Response to Planning Application

From: Arun District Council Greenspace

Application ref: WA/48/19/RES

Location: Land to the East of Fontwell Avenue Fontwell Avenue Fontwell

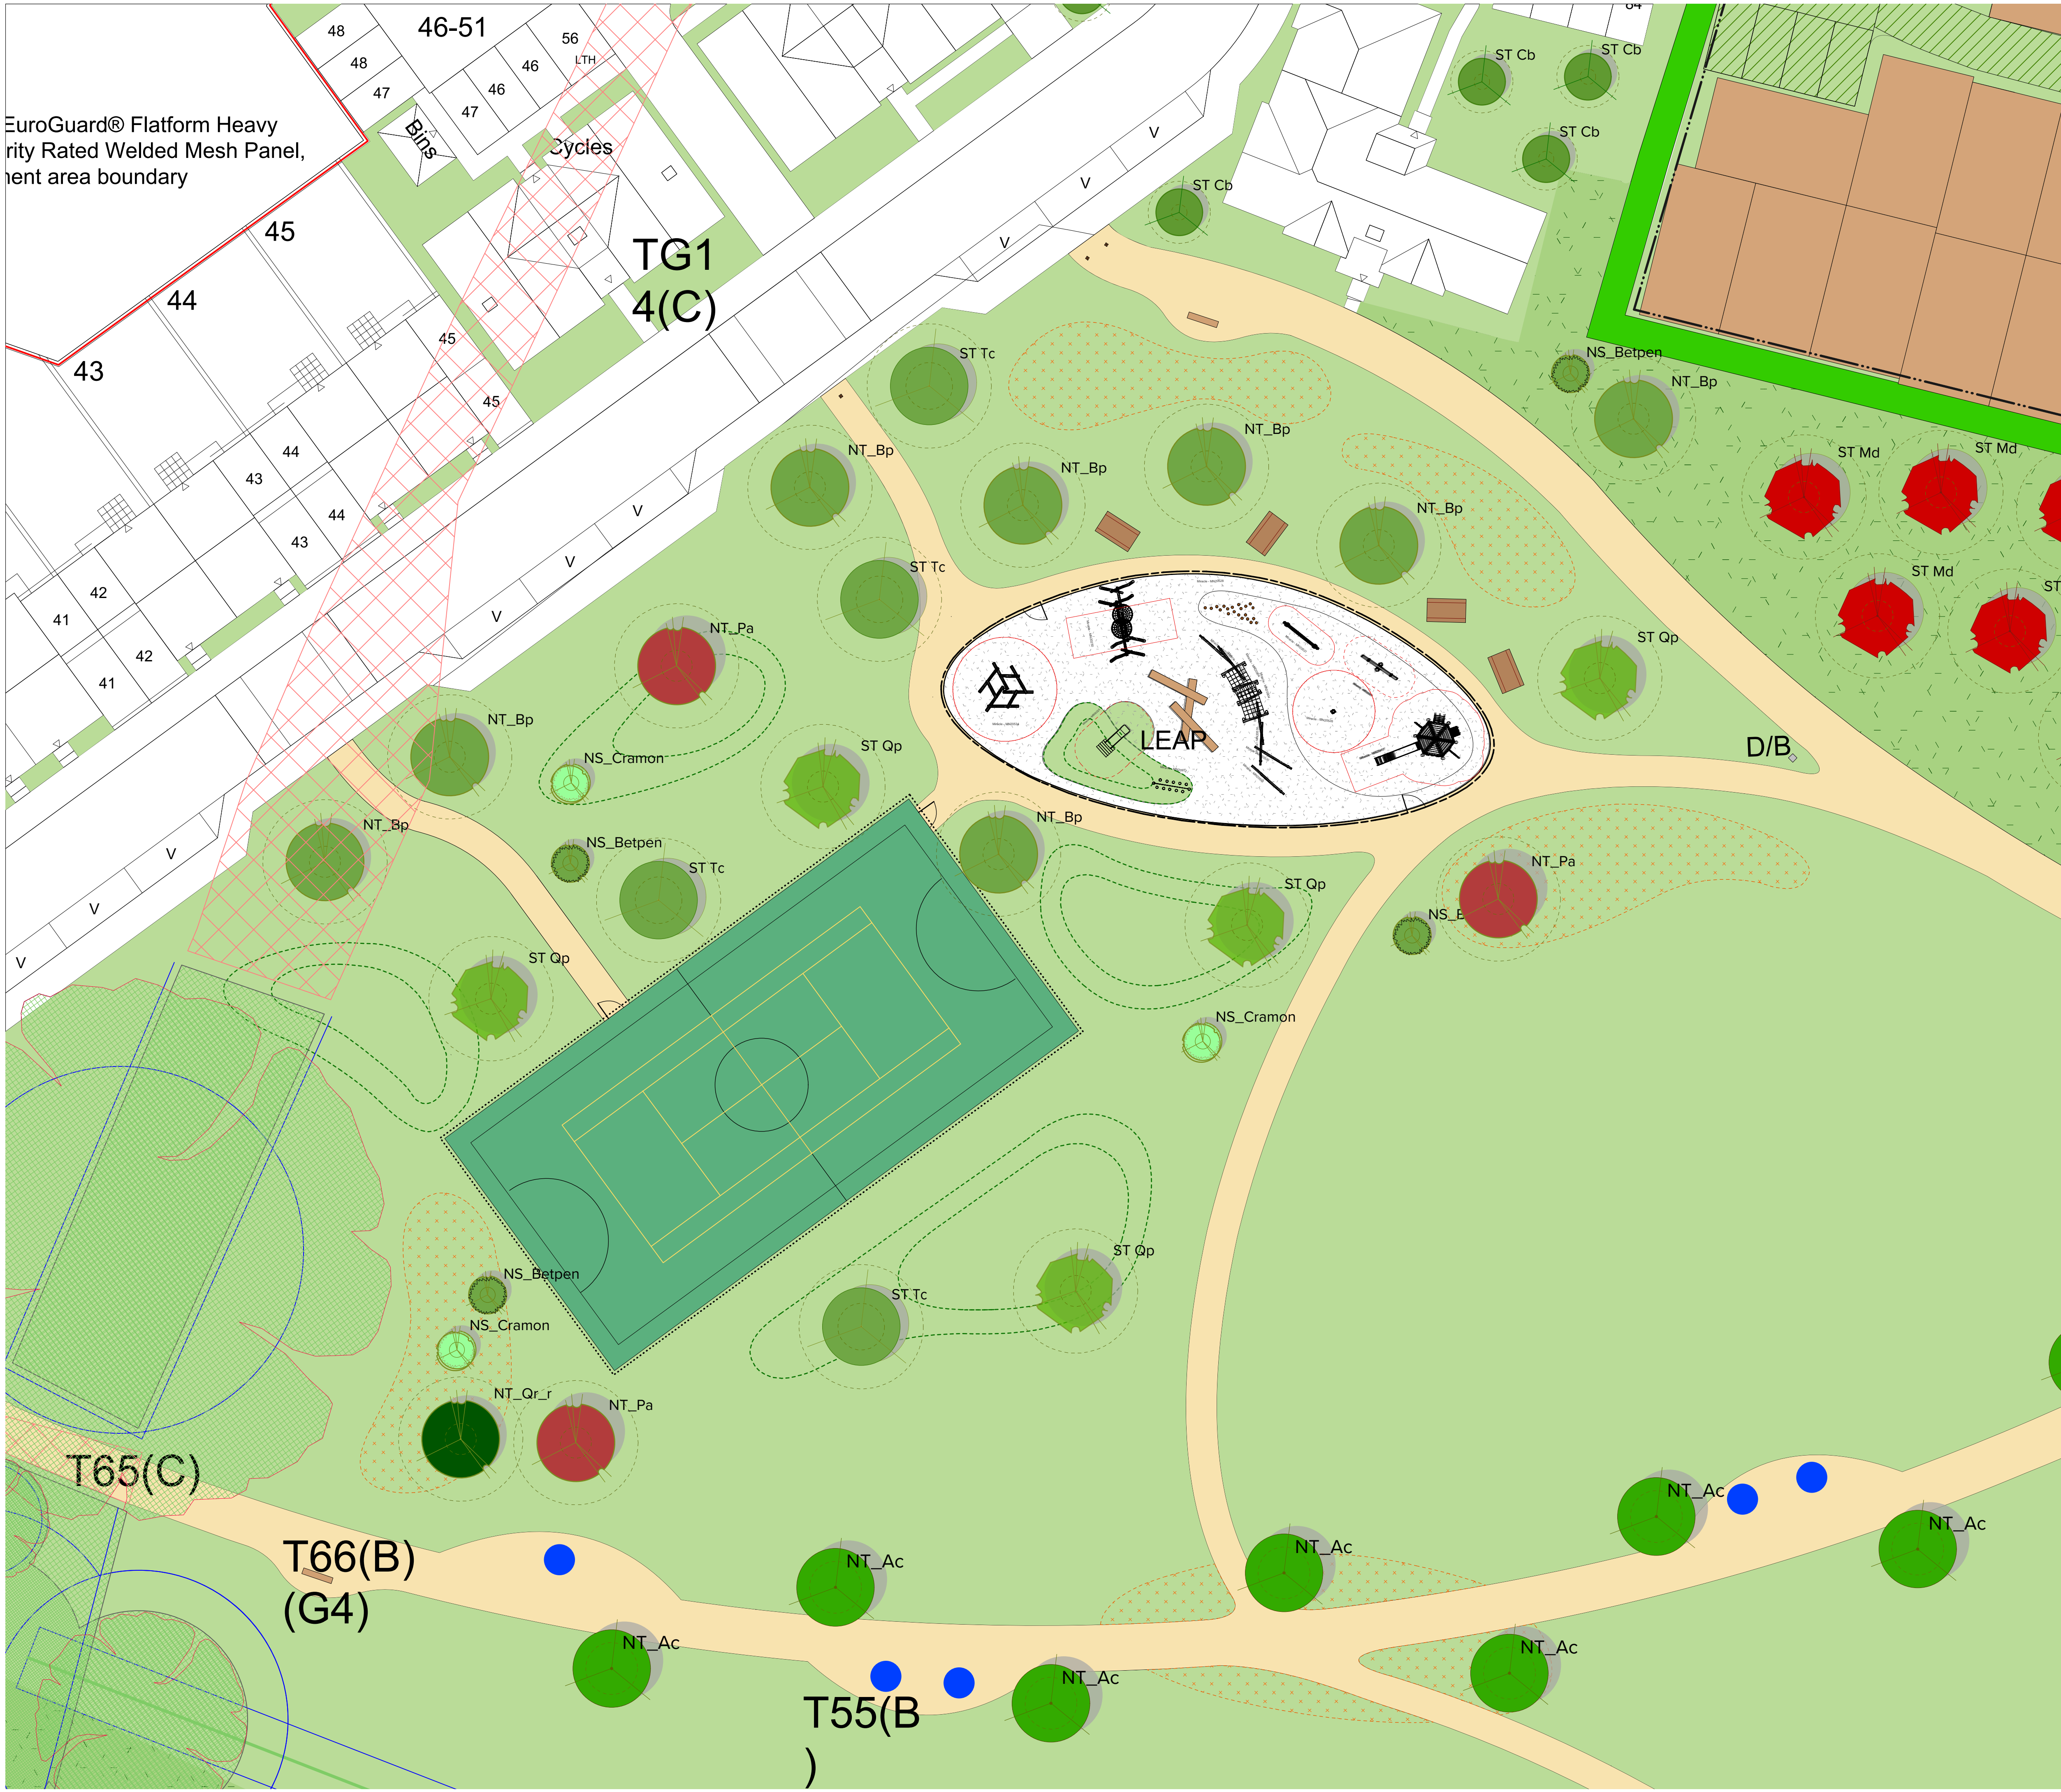
- Outdoor Gym equipment – Clarification to be provided re the full range of equipment being specified? Are these all adult size pieces or are any of these child size items too? The location of these within the pathways will require careful consideration and will need to be clearly defined as these can be a danger within pathways particularly to cyclists in low light level situations. We would recommend that these items are placed adjacent but not within main pathways.

- LEAP – are any of the pieces classified as inclusive as for a development of this many dwellings it would be good to see consideration having been given to this. We would want to see also that the proposed MUGA has DDA compliant access.

- Play area surfacing is indicated as Play Bark. This should be re-considered from a maintenance liability point of view. The LPA would not be supportive of Play Bark if it were to be responsible for maintenance and management with alternative suitable non loose-fill material required.

- The Southern Masterplan shows an Attenuation Pond and concerningly balance logs and glacial boulders positioned within the edge of this SuDS feature. The LPA cannot support the positioning of these within such close proximity to a water body (albeit intermittent water holding or not) due to the potential danger indicating play here poses. We would require that these are omitted from this location and repositioned where they are not in any close proximity to water. We would request that RoSPA or similar body are consulted re play in relation to water across the whole of this site.
